MARKSHEFFEL CROSSING- AIRPORT OVERLAY

JUNE 2026

V1_Noise study addressing Airport Noise.pdf Markup Summary

HAZARDS AND CONSTRAINTS

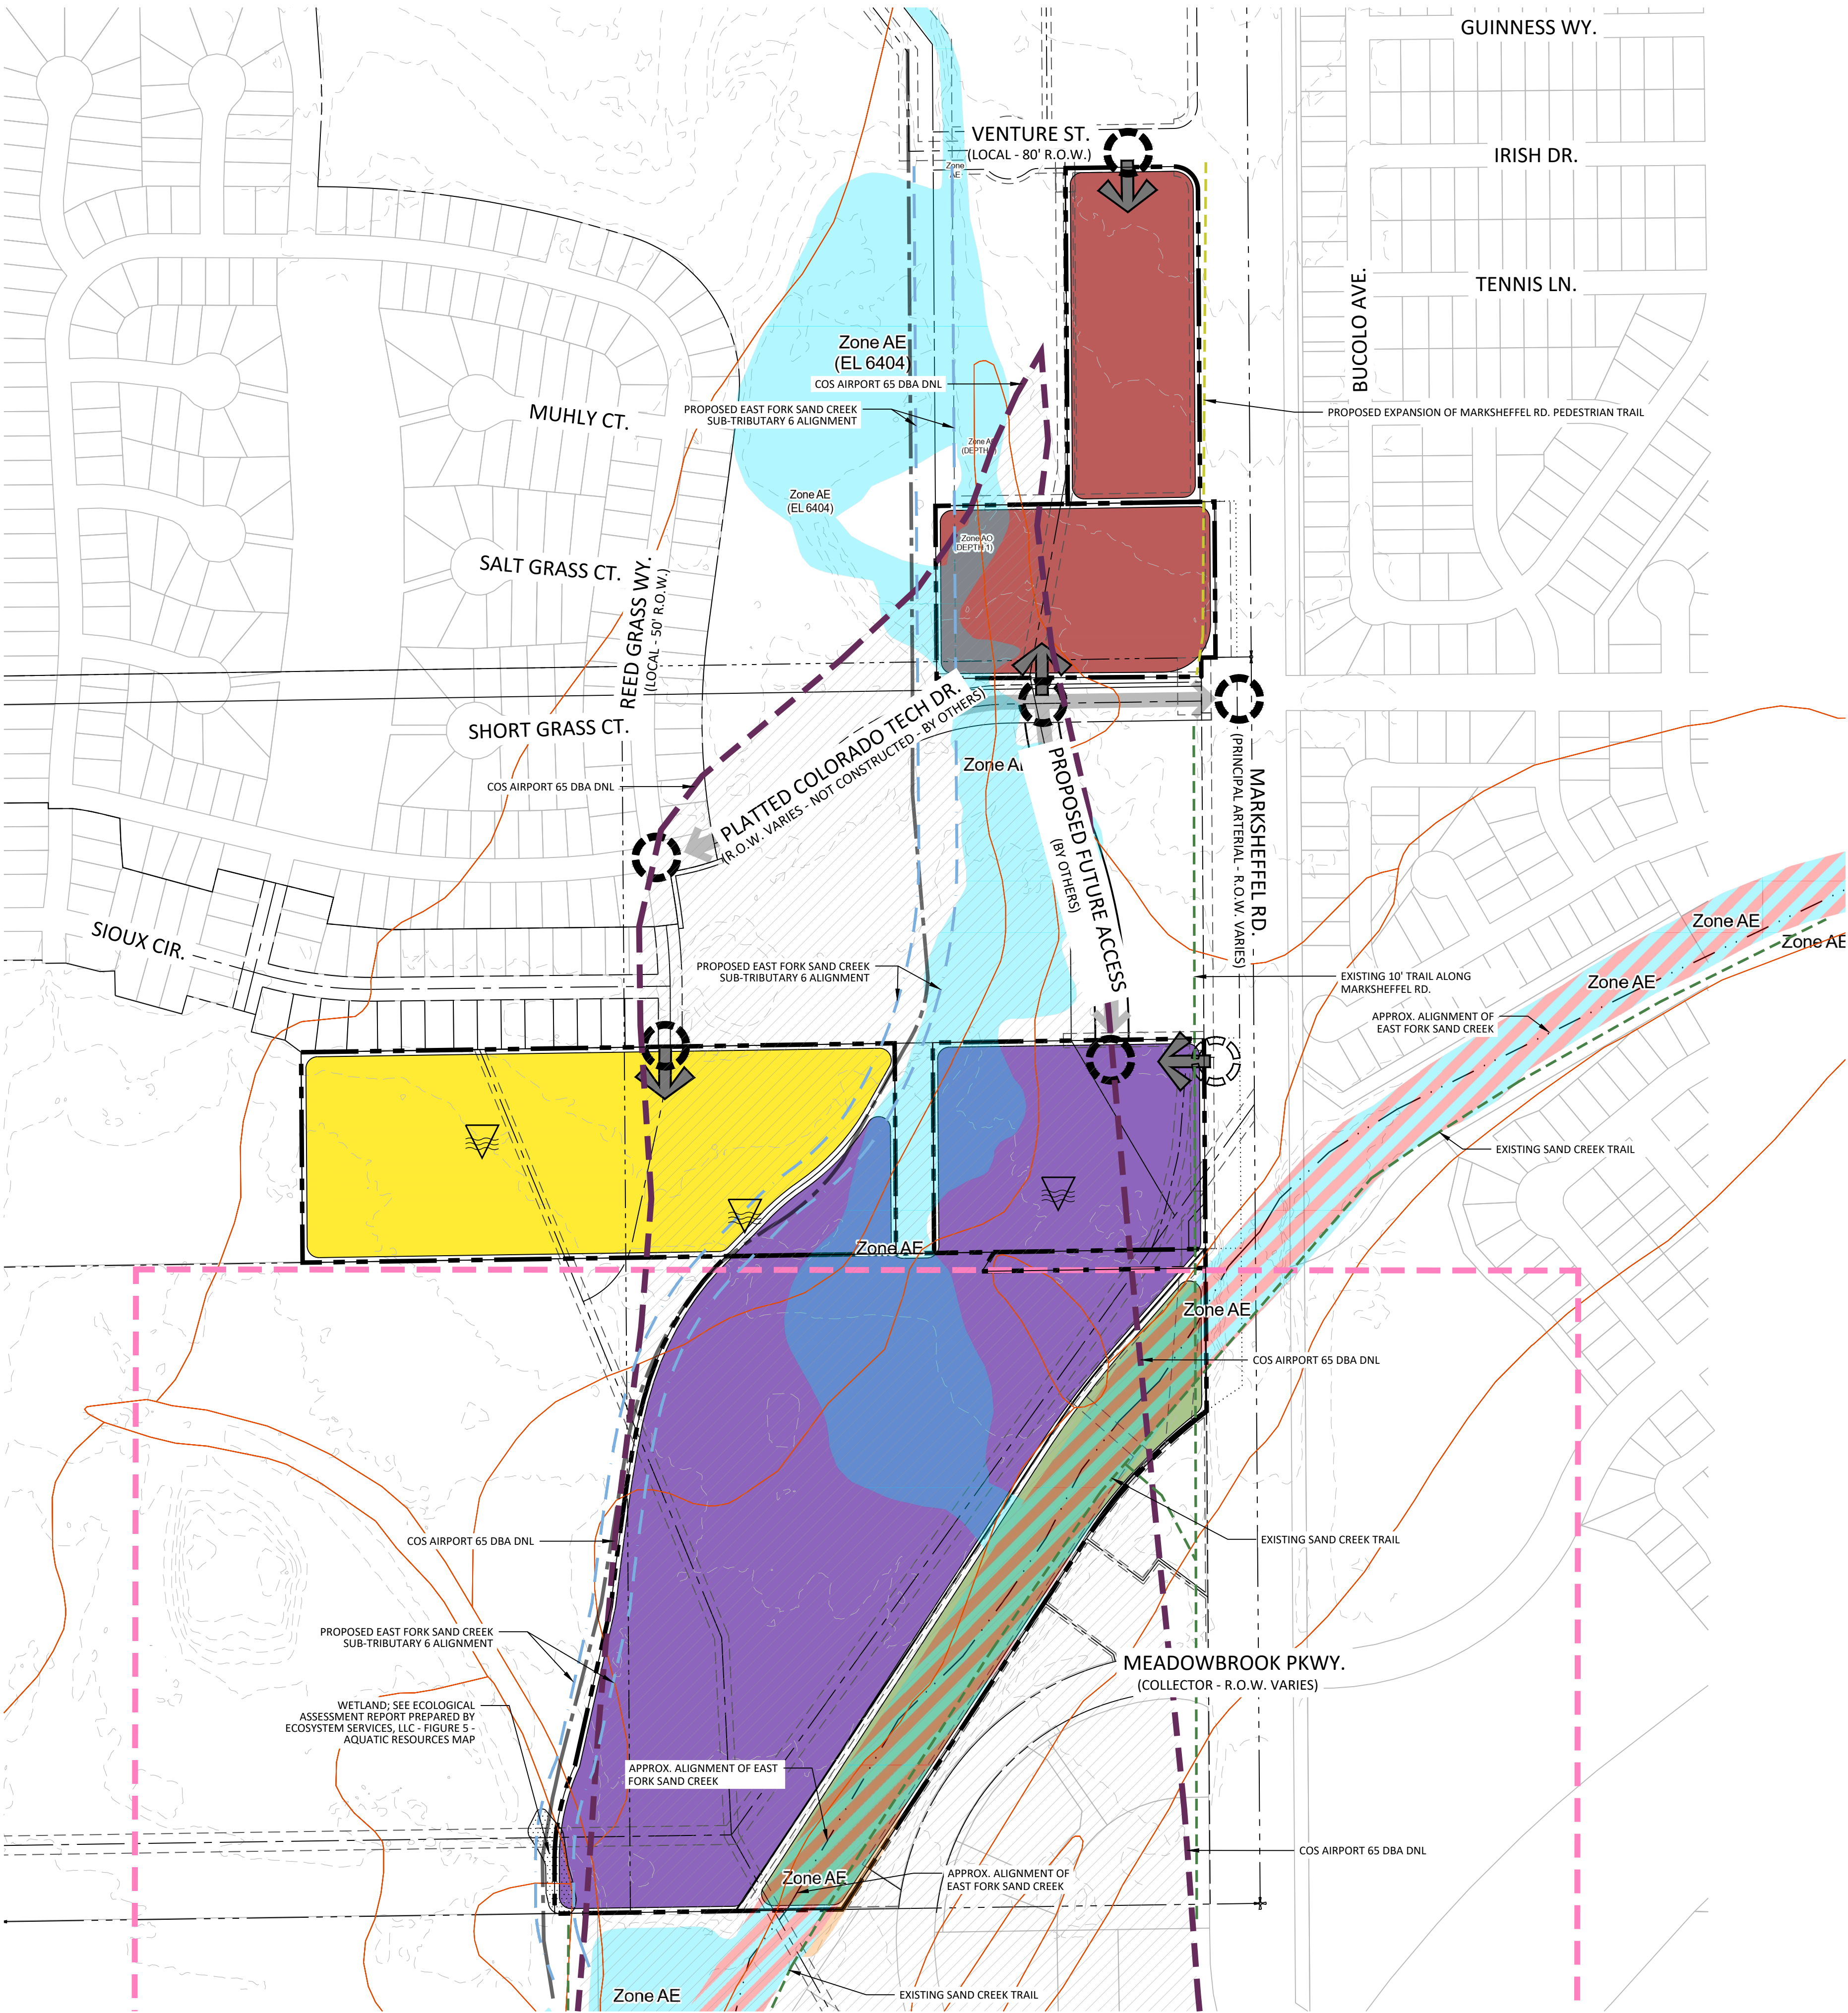
Is this area encompassing the north and south portions of the sketch plan or is it just the south parcels? Map should include the north and south portions of the sketch plan for reference.

update this map to show the SKP area

CAD_O and ADNL and APZ2

this noise study prepared by a qualified engineer or acoustical specialist needs to address the airport noise for the sketch plan area, and mitigation to be followed in support of the Sketch Plan meeting the CAD_O overlay in the Code.
